# CITY OF ALBUQUERQUE

**Re: ABQ Healthcare for the Homeless Grading Plan, 1220 1<sup>st</sup> St.  
Engineer's Stamp dated 12-12-2012 (J-14/D172)**

Based upon the information provided in your submittal dated 12-13-2012, the above referenced plan is approved for Grading Permit. Prior to the future Building Permit approval please address the following comments:

GRADING PLAN

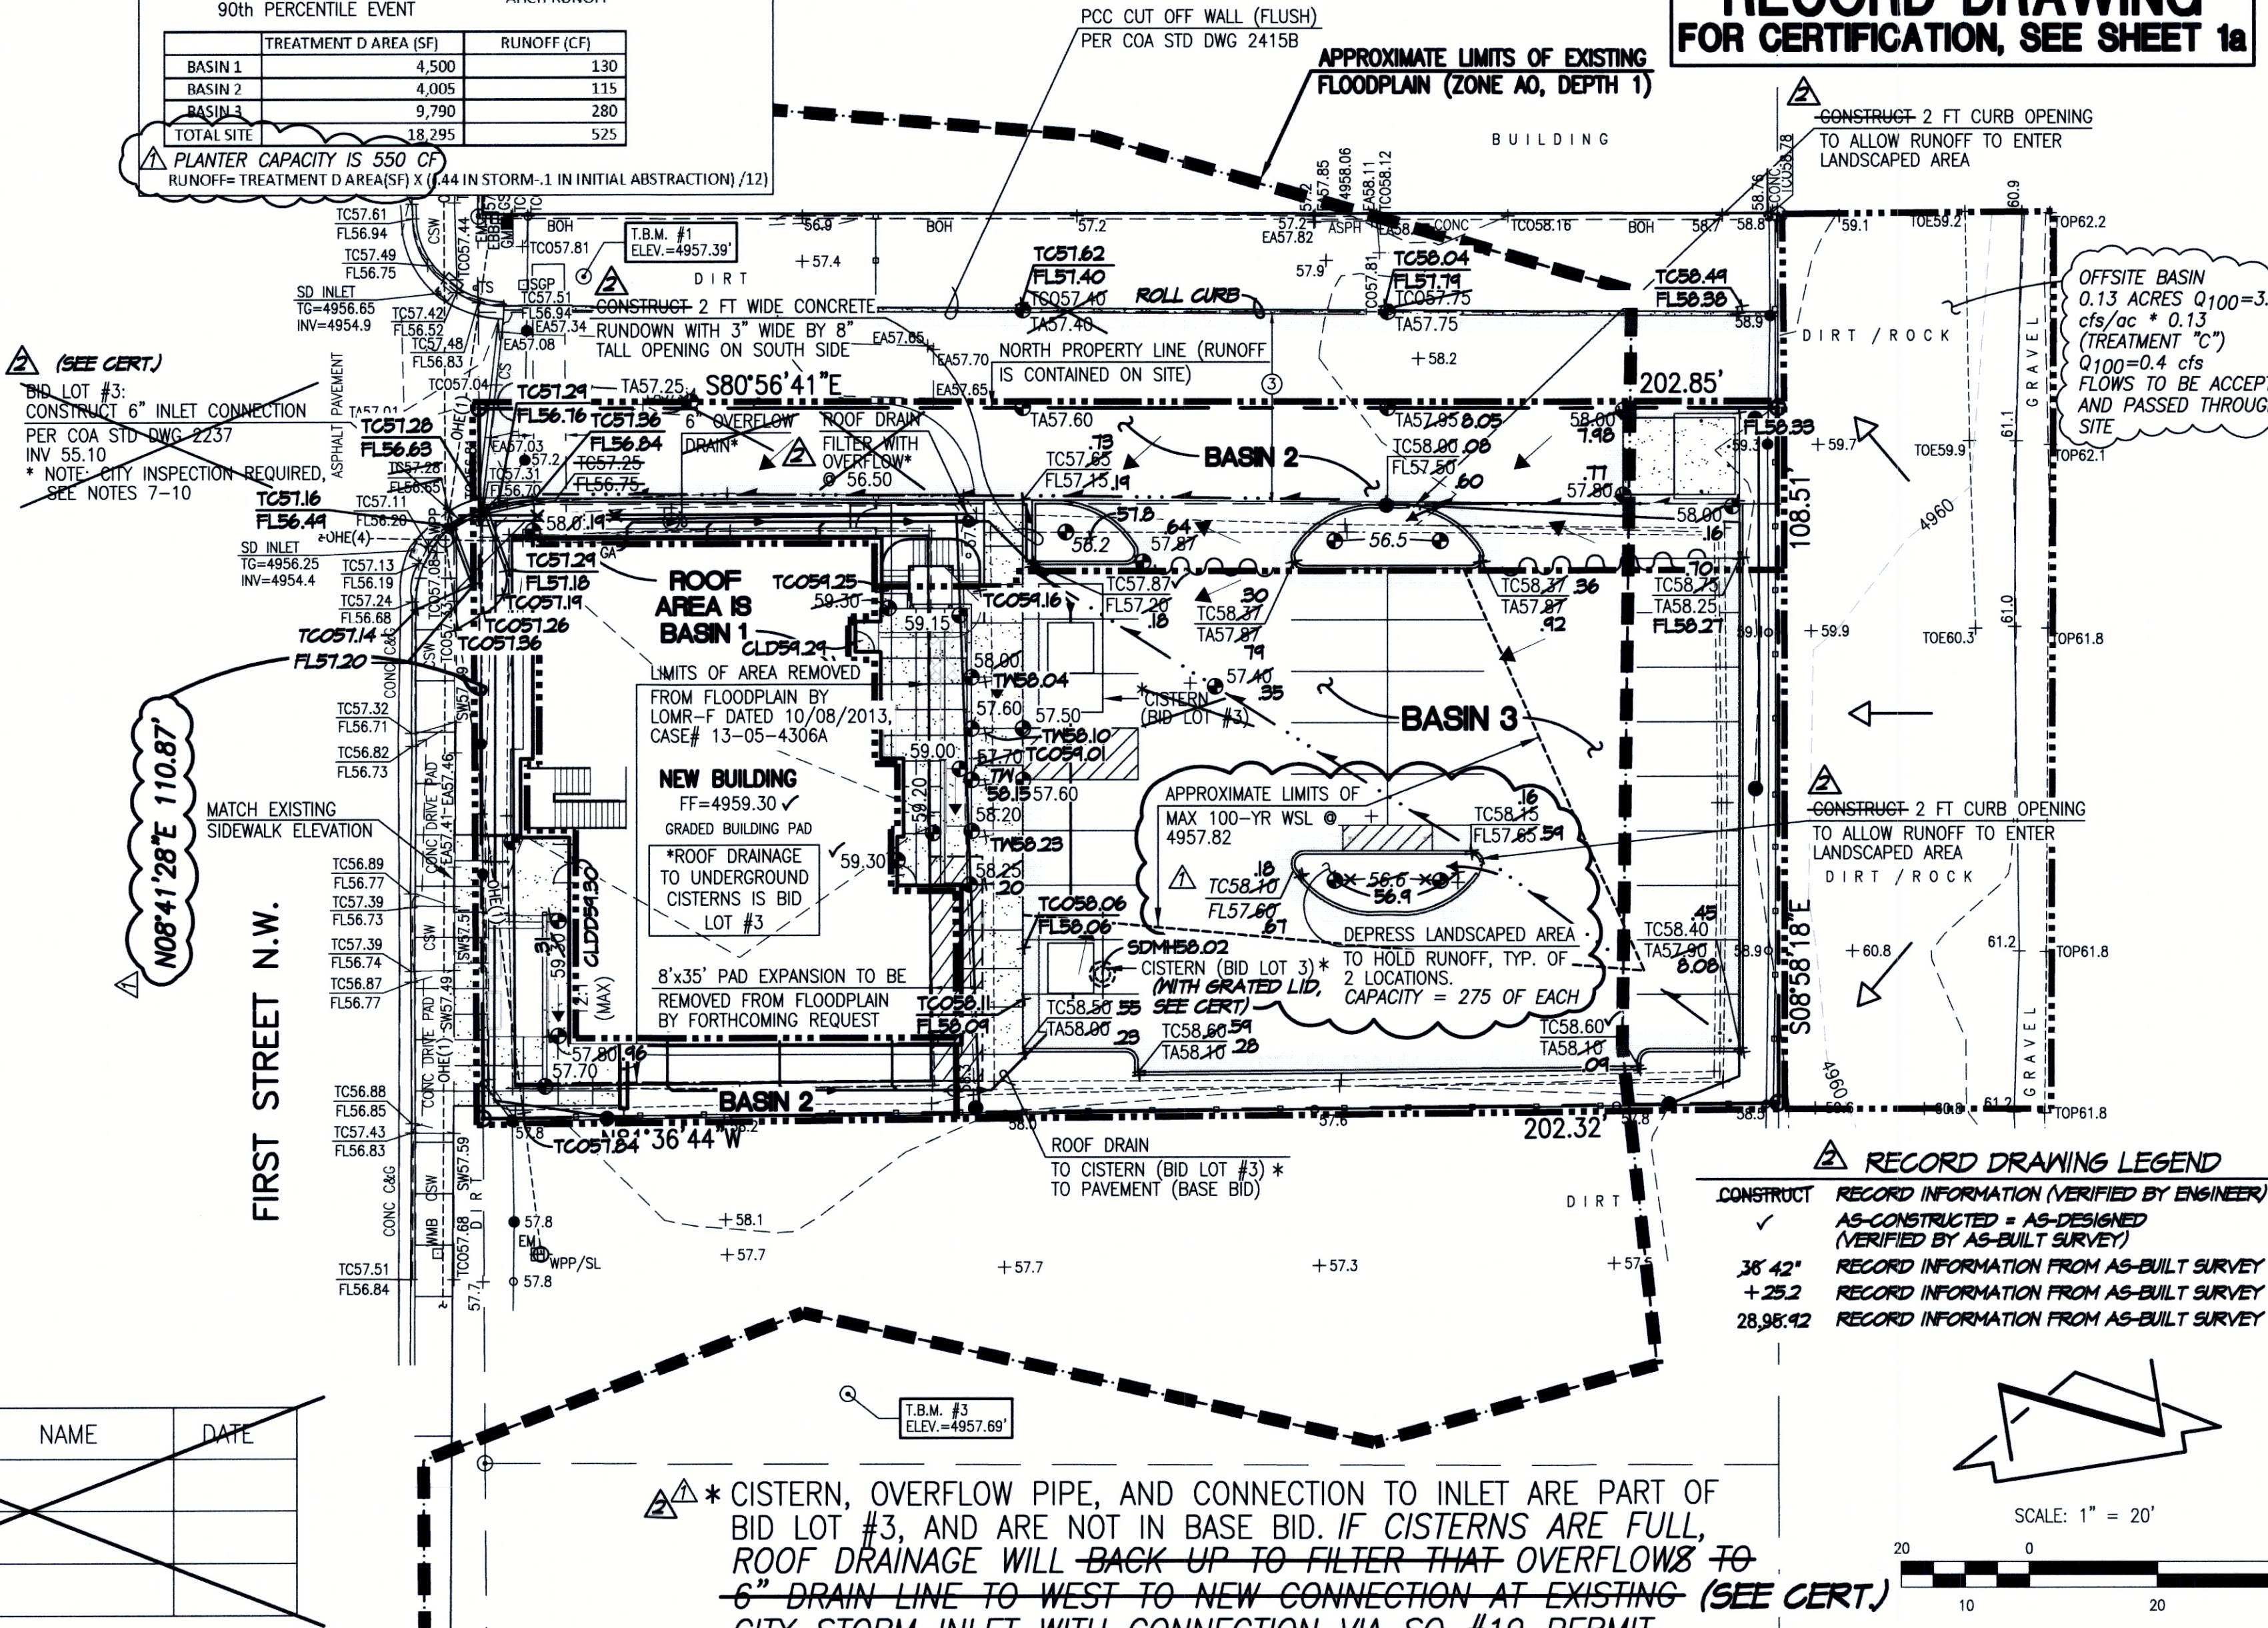
- Is the access easement along the northern property edge a drainage easement as well?
- It appears that flows will cross the property line along the southern boundary at the building pad. Please clarify how these flows will be directed.
- Runoff volumes for this site will be required to be limited to 2.75 cfs/acre for future development.
